My reference: 3/2021/0042
Direct Dial: (01200) 425111
www.ribblevalley.gov.uk
Email: planning@ribblevalley.gov.uk
Date: 23 February 2021

Location: Banks Cottage Chipping Road Longridge PR3 2NB
Proposal: Discharge of condition 7 (drop kerb and site access) from planning permission 3/2020/0689.

Condition 7 - Dropped Kerb and Site Access

PROPOSED SITE PLAN-2

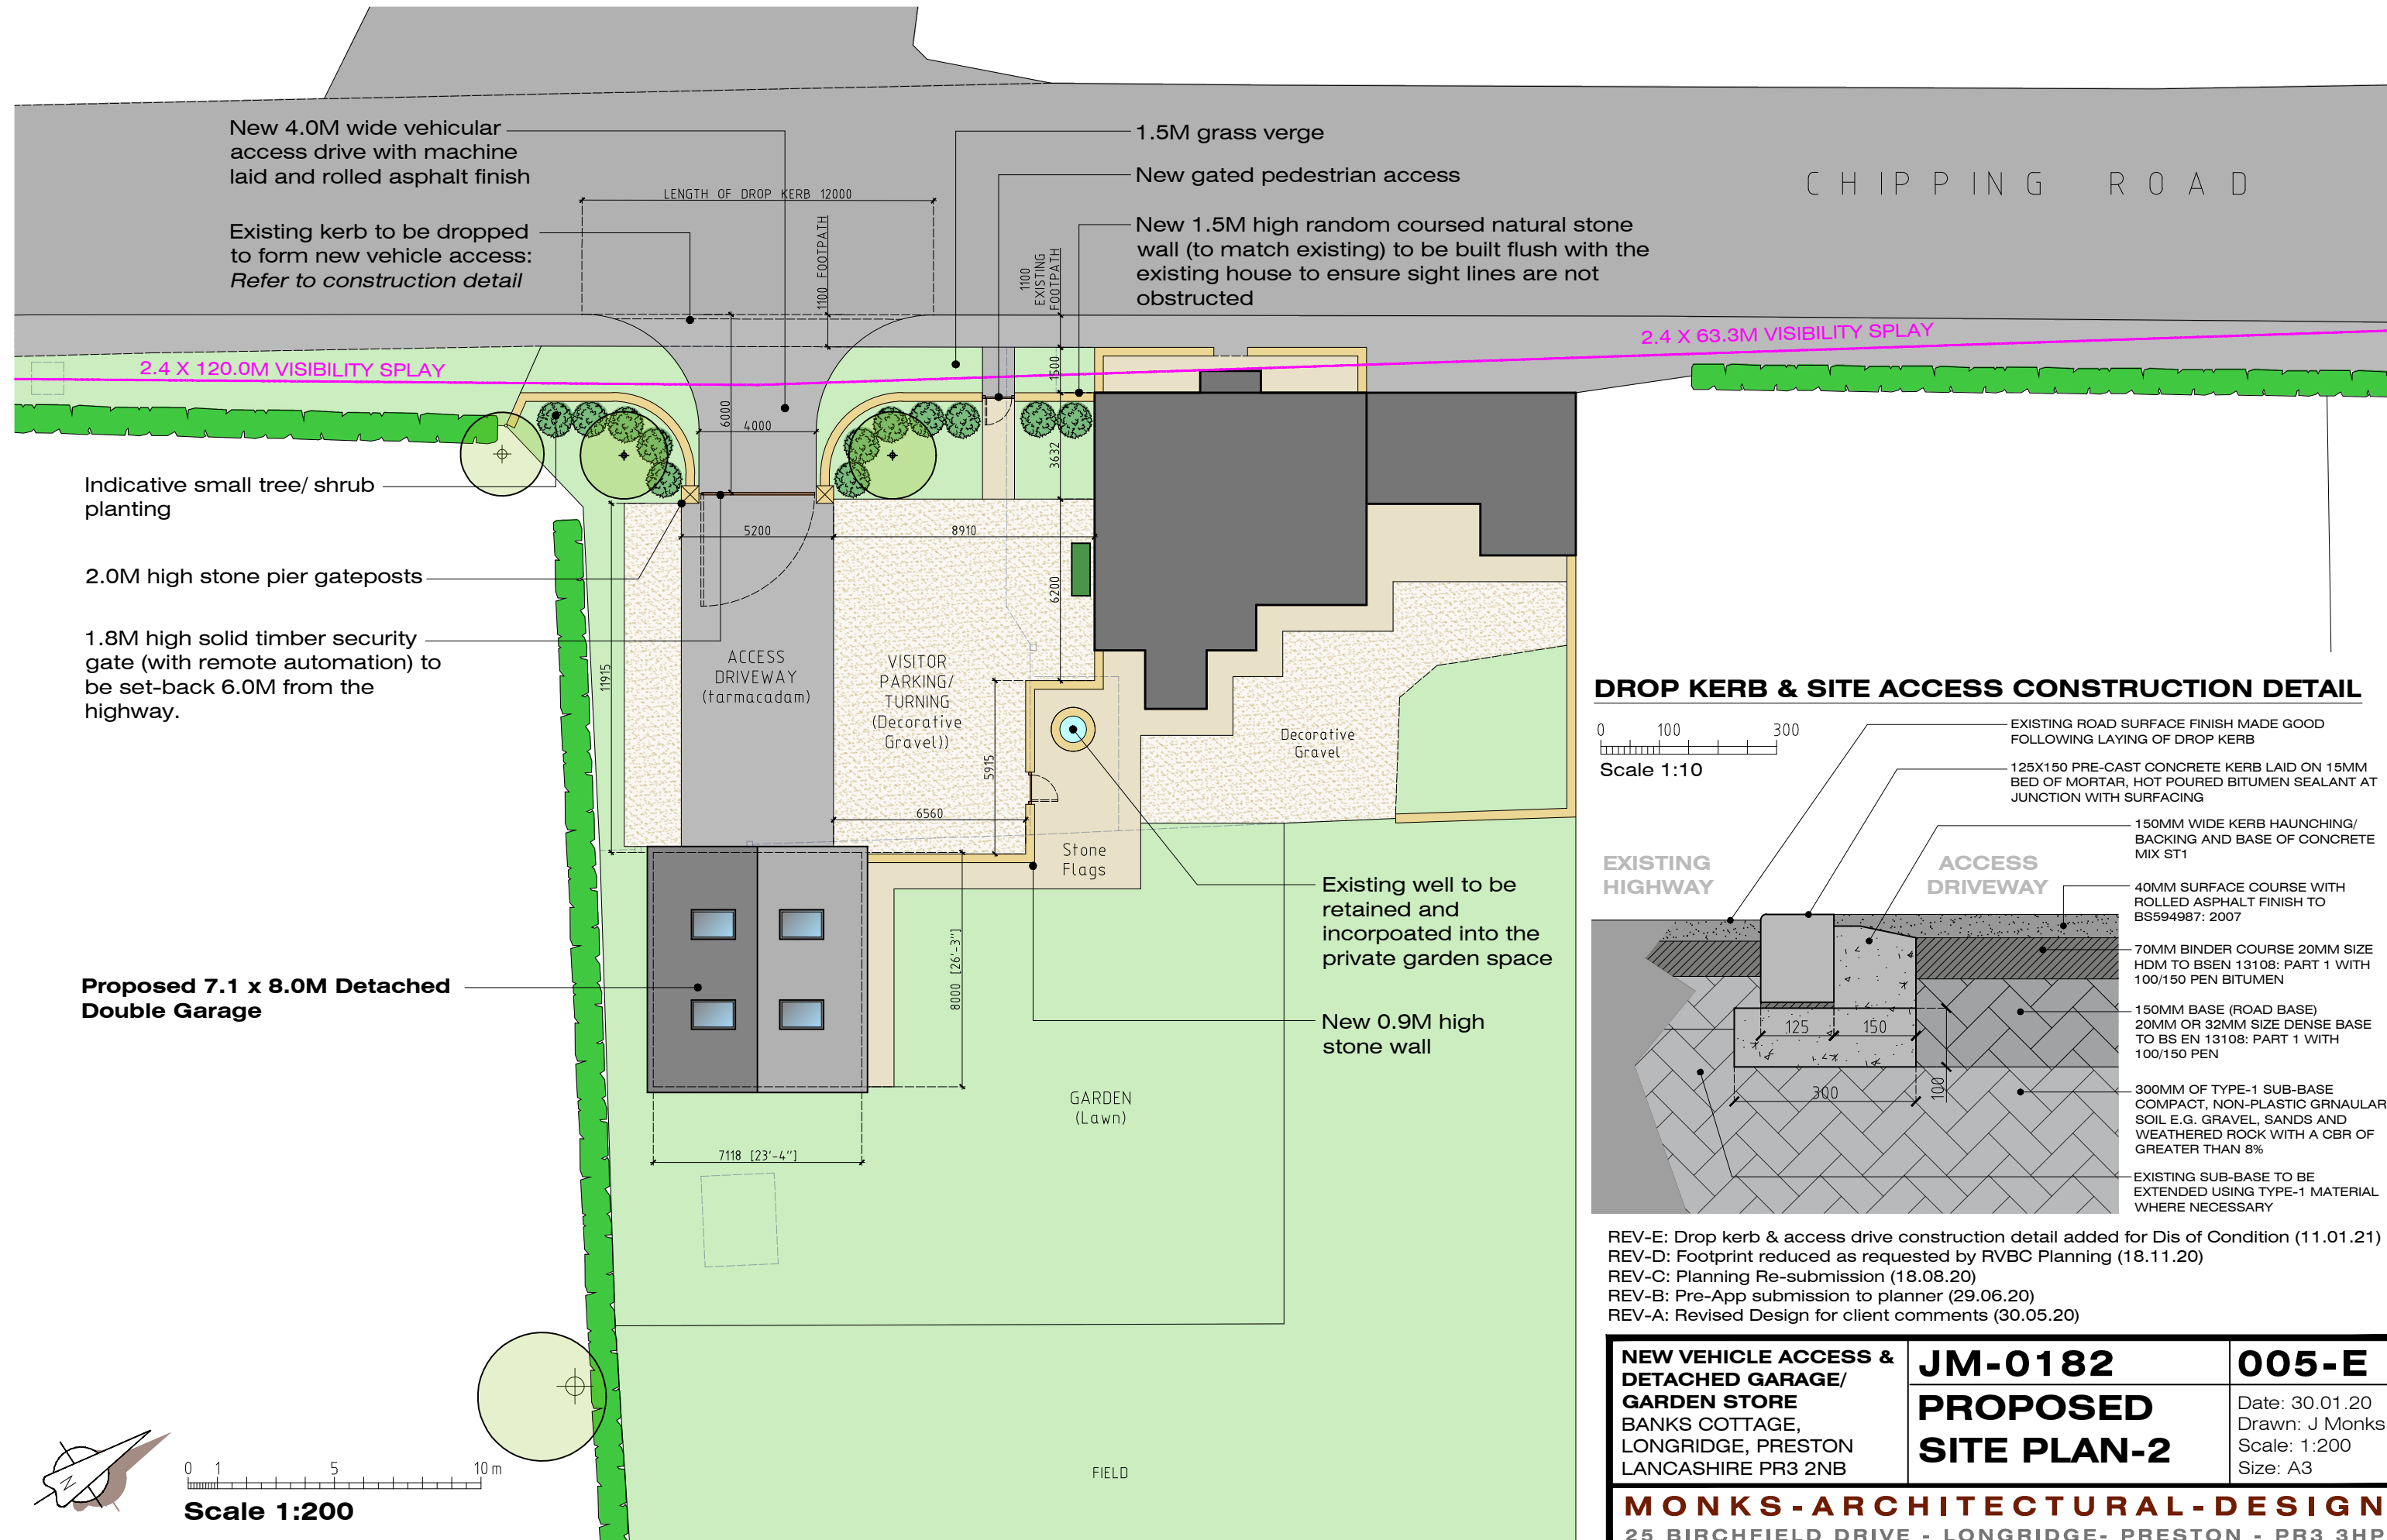
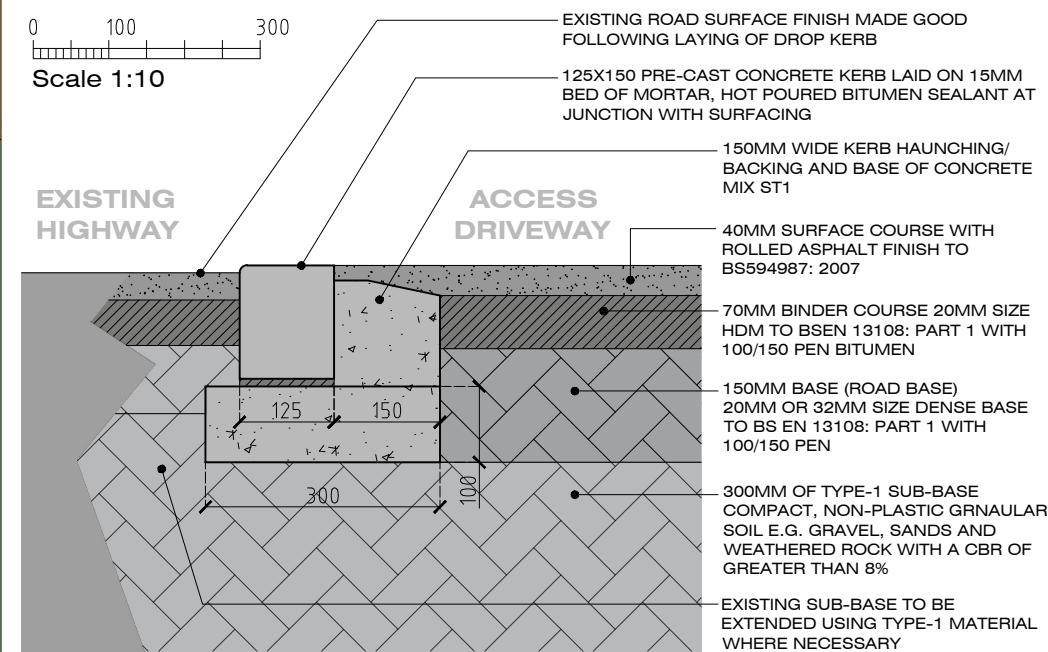
Condition 7 is partially discharged, the submitted proposed site plan ref JM-0182-005-D dated 30.1.20, showing the site access and offsite works to form the dropped kerb, is considered acceptable.

The condition requires that the development be carried out in accordance with the approved details and thereafter retained as such.

The applicant is also required to applicant to enter into an appropriate legal agreement (Section 278), with Lancashire County Council as Highway Authority prior to the start of any development. The applicant should be advised to contact the county council for further information by telephoning the Development Support Section on 0300 123 6780 or email develooperas@lancashire.gov.uk, in the first instance to ascertain the details of such an agreement and the information to be provided, quoting the location, district and relevant planning application reference number.
